DRAINAGE AND TRANSPORTATION INFORMATION SHEET

Project Title: THE GEORGE **Building Permit #** **Hydrology File #**

RE: 170 Central Ave.- The George

I have reviewed your comments provided on August 10, 2023 and have provided responses to your comments below.

B1 TRAFFIC CONTROL LAYOUT PLAN
1"=20'-0"

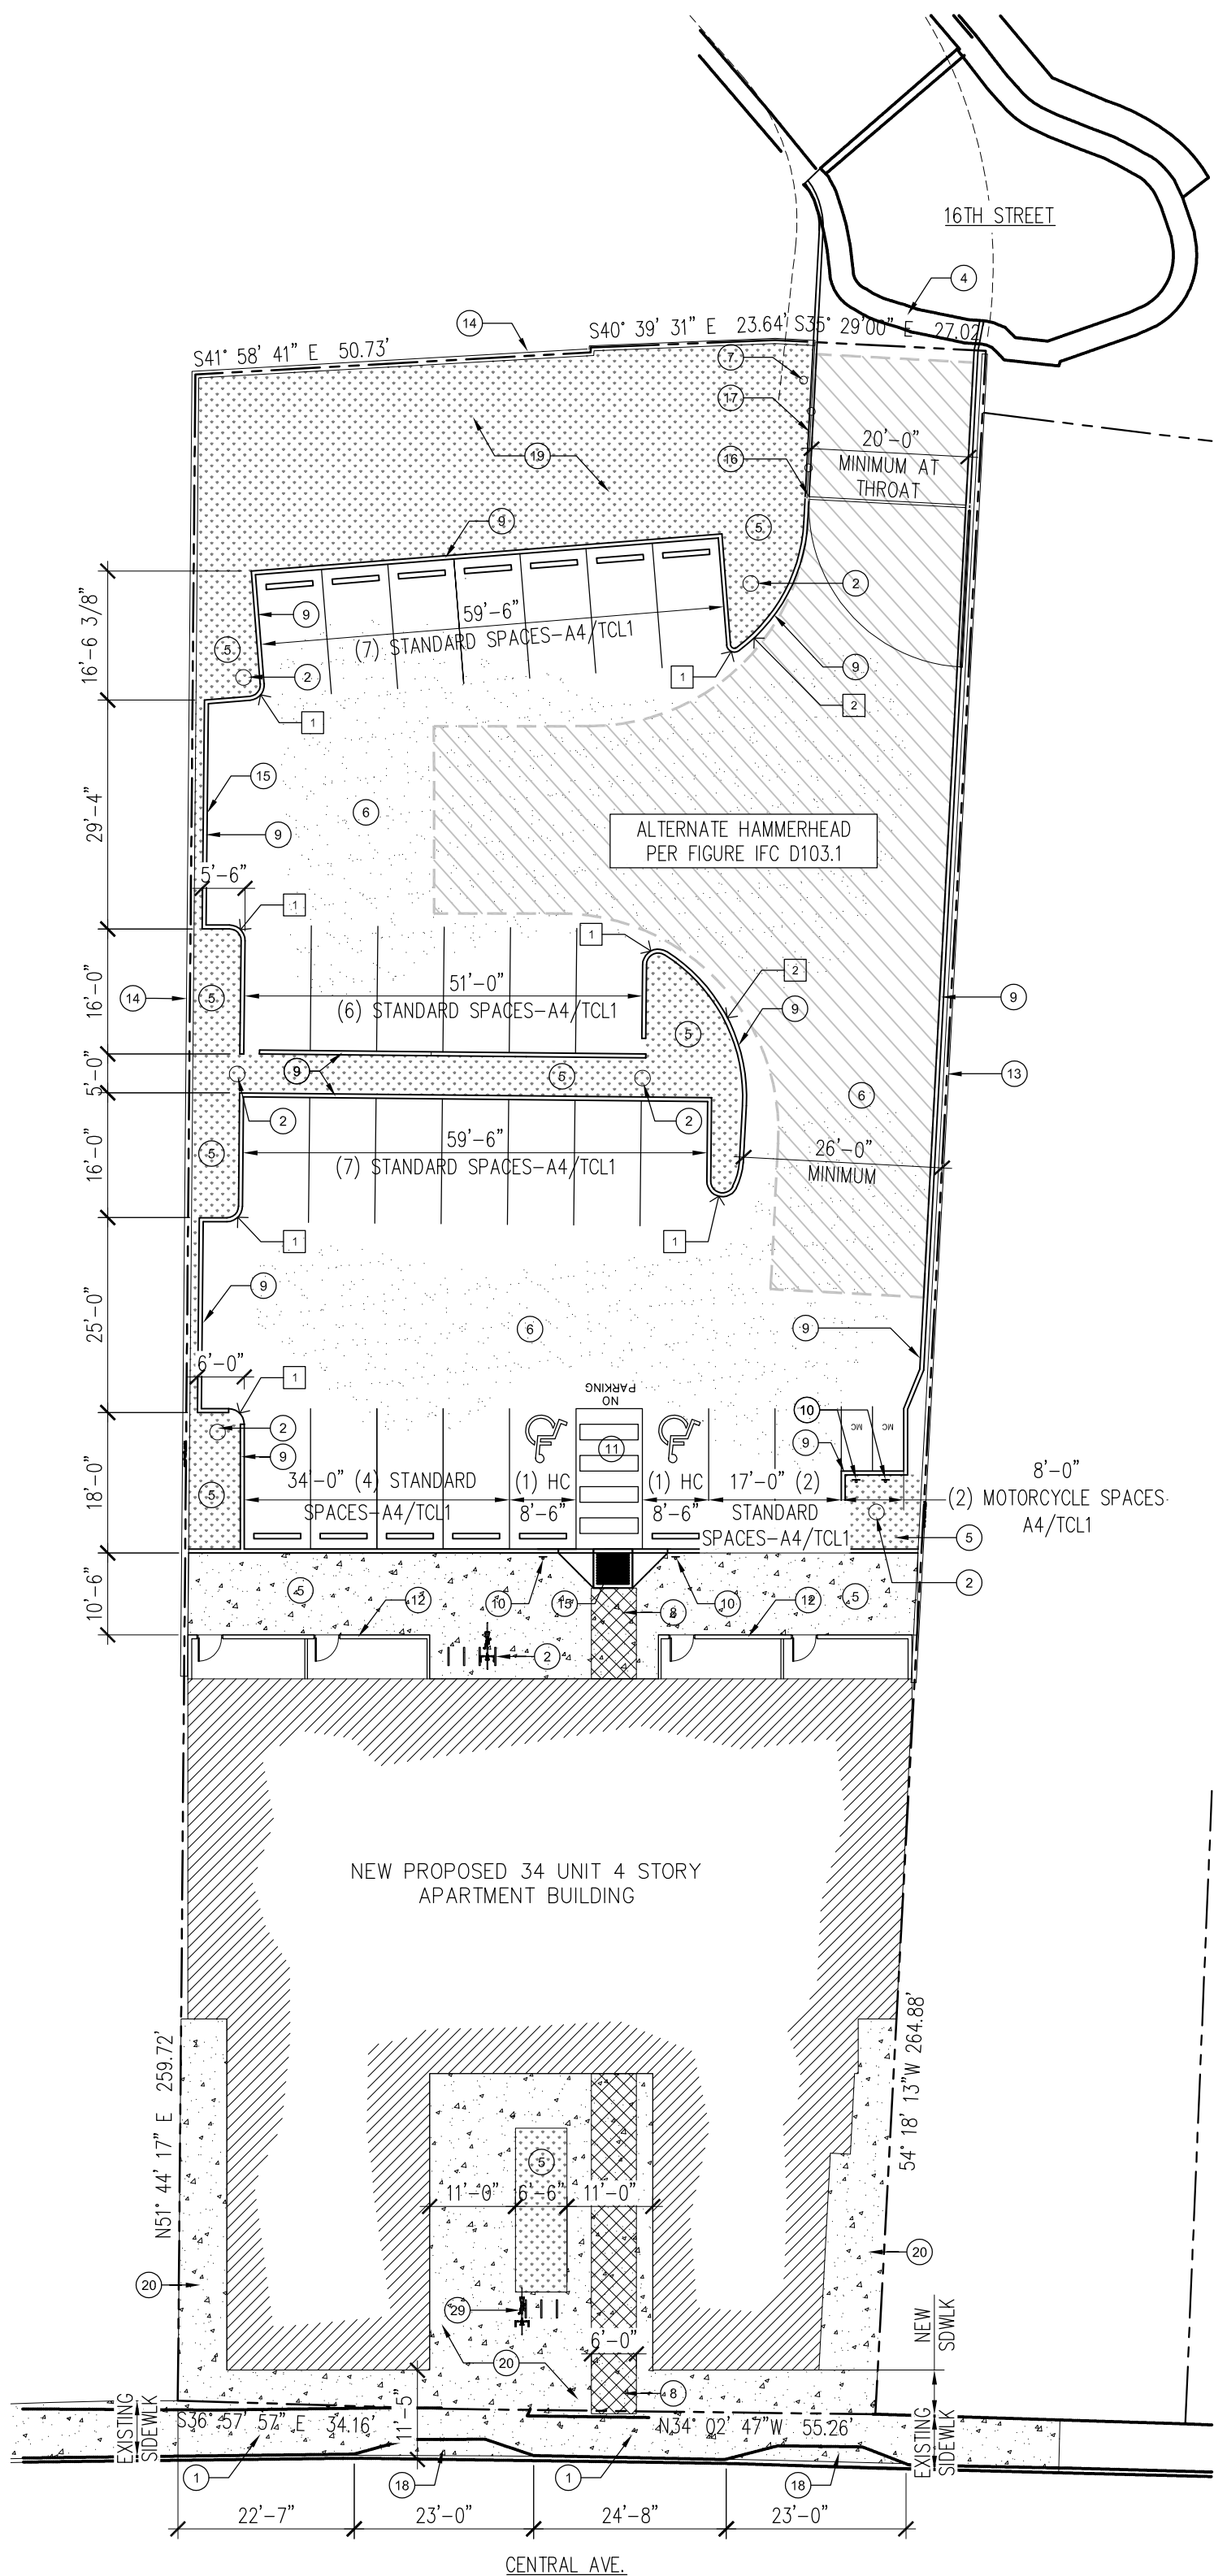
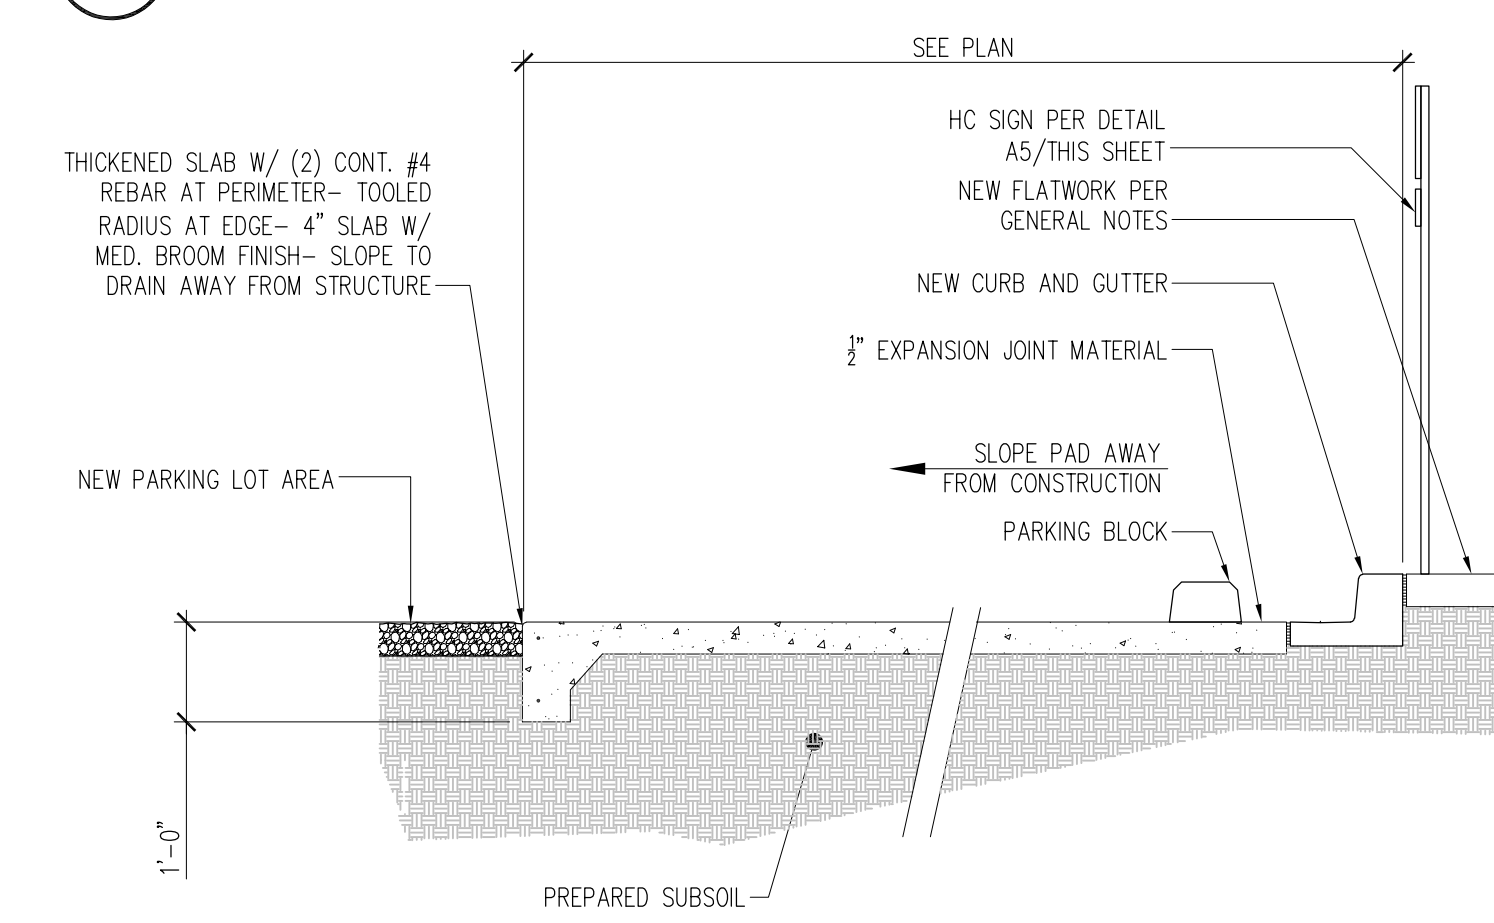
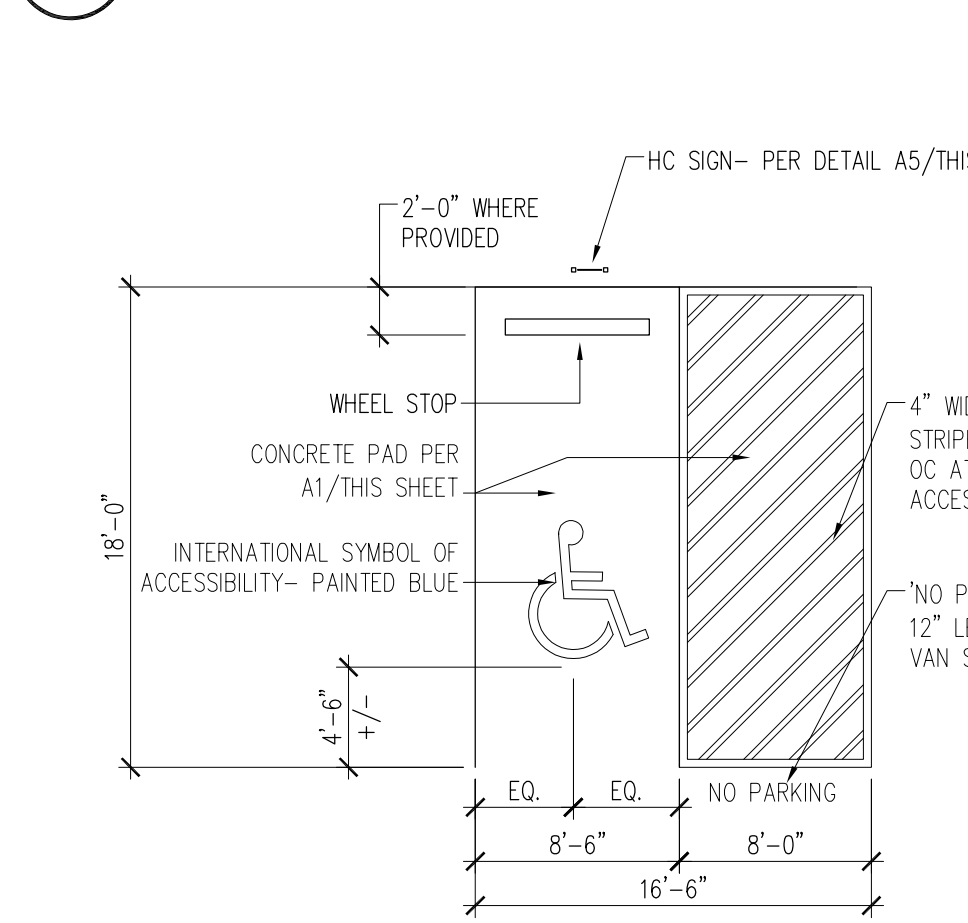
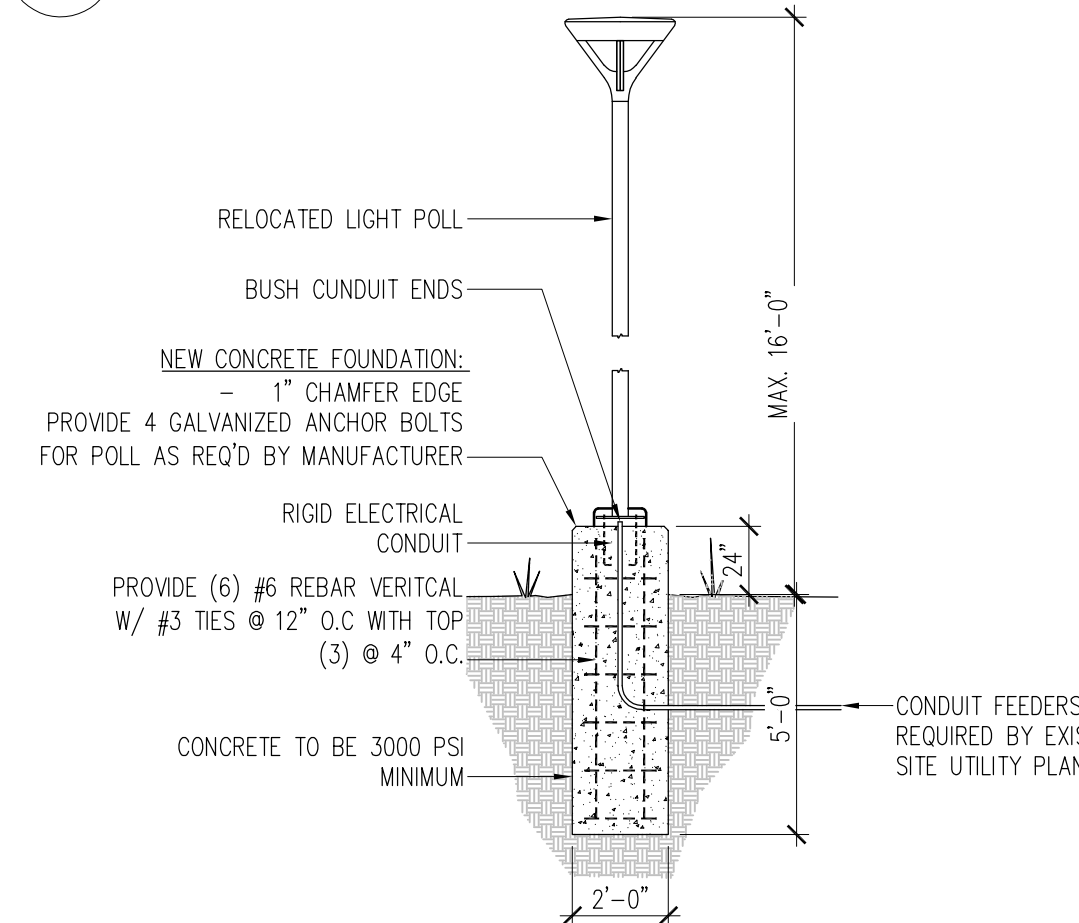
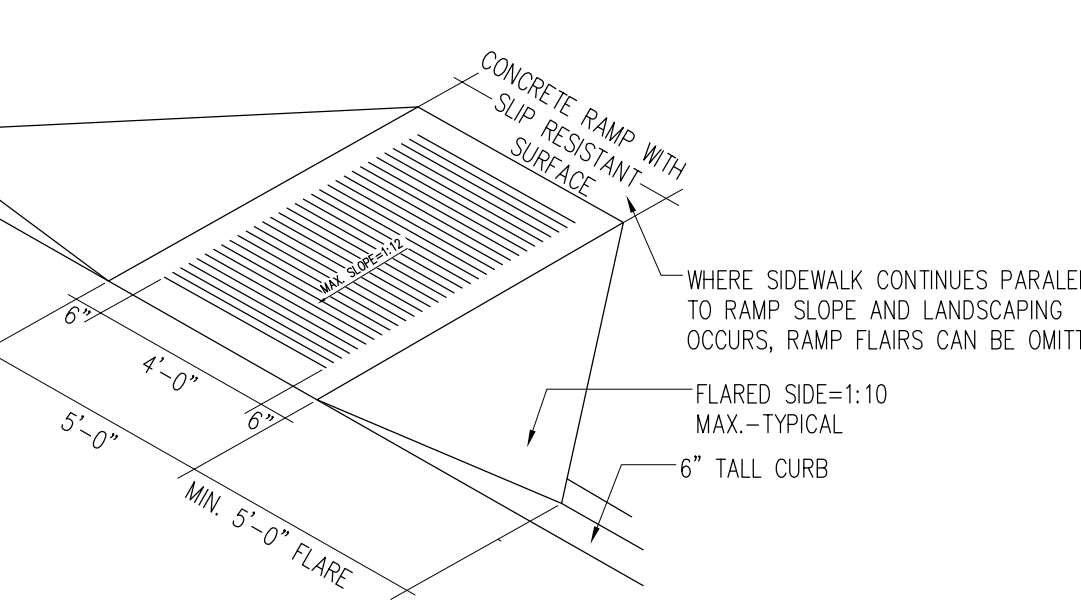
1. Please show on the site plan the north direction to determine the orientation of the site.
Response: North arrow has been added.
2. Identify all existing access easements and right of way widths.

Response: Right-of-way widths and road widths have been added for your use.
3. Identify the right-of-way widths medians curb cuts and street widths on central and 16th St.

Response: Signed shared parking agreement is pending.
5. Site access must be built per city standard.
Response: Keyed note #4 has been revised to include reference to COA standard drawing #2415B

6. Keyed note 18: Please reference COA STD DWG 2430. It appears that there is a water meter in the public sidewalk by the construction area off Central. Please contact Water Authority for a permit.

7. Please define keyed note #29.

9. Show the clear site triangle and the following note to the plan: "Landscaping and signage will not interfere with clear sight requirements. Therefore, signs, walls, trees, and shrubbery between 3 and 8 feet tall (as measured from the gutter pan) will not be acceptable in the clear sight triangle.

11. Add a note stating "All broken or cracked sidewalk must be replaced with sidewalk and curb & gutter." A build note must be provided referring to the appropriate City Standard drawing.

Response: Information has been added as requested. See also response #2.
4. Shared Parking Agreement must be approved and signed by director Alan Varela and City authorized notary.

Response: Keyed note #18 has been revised to include reference to COA standard detail 2430. Note this is also referenced in the general notes. Water Meter will be relocated and permitted at time of construction.

Response: Keyed note #29 has been removed from the drawing.

Response: The note is included in the TCL General Notes Sheet TCL01.

Response: This note is included in the TCL General Notes sheet TCL1.
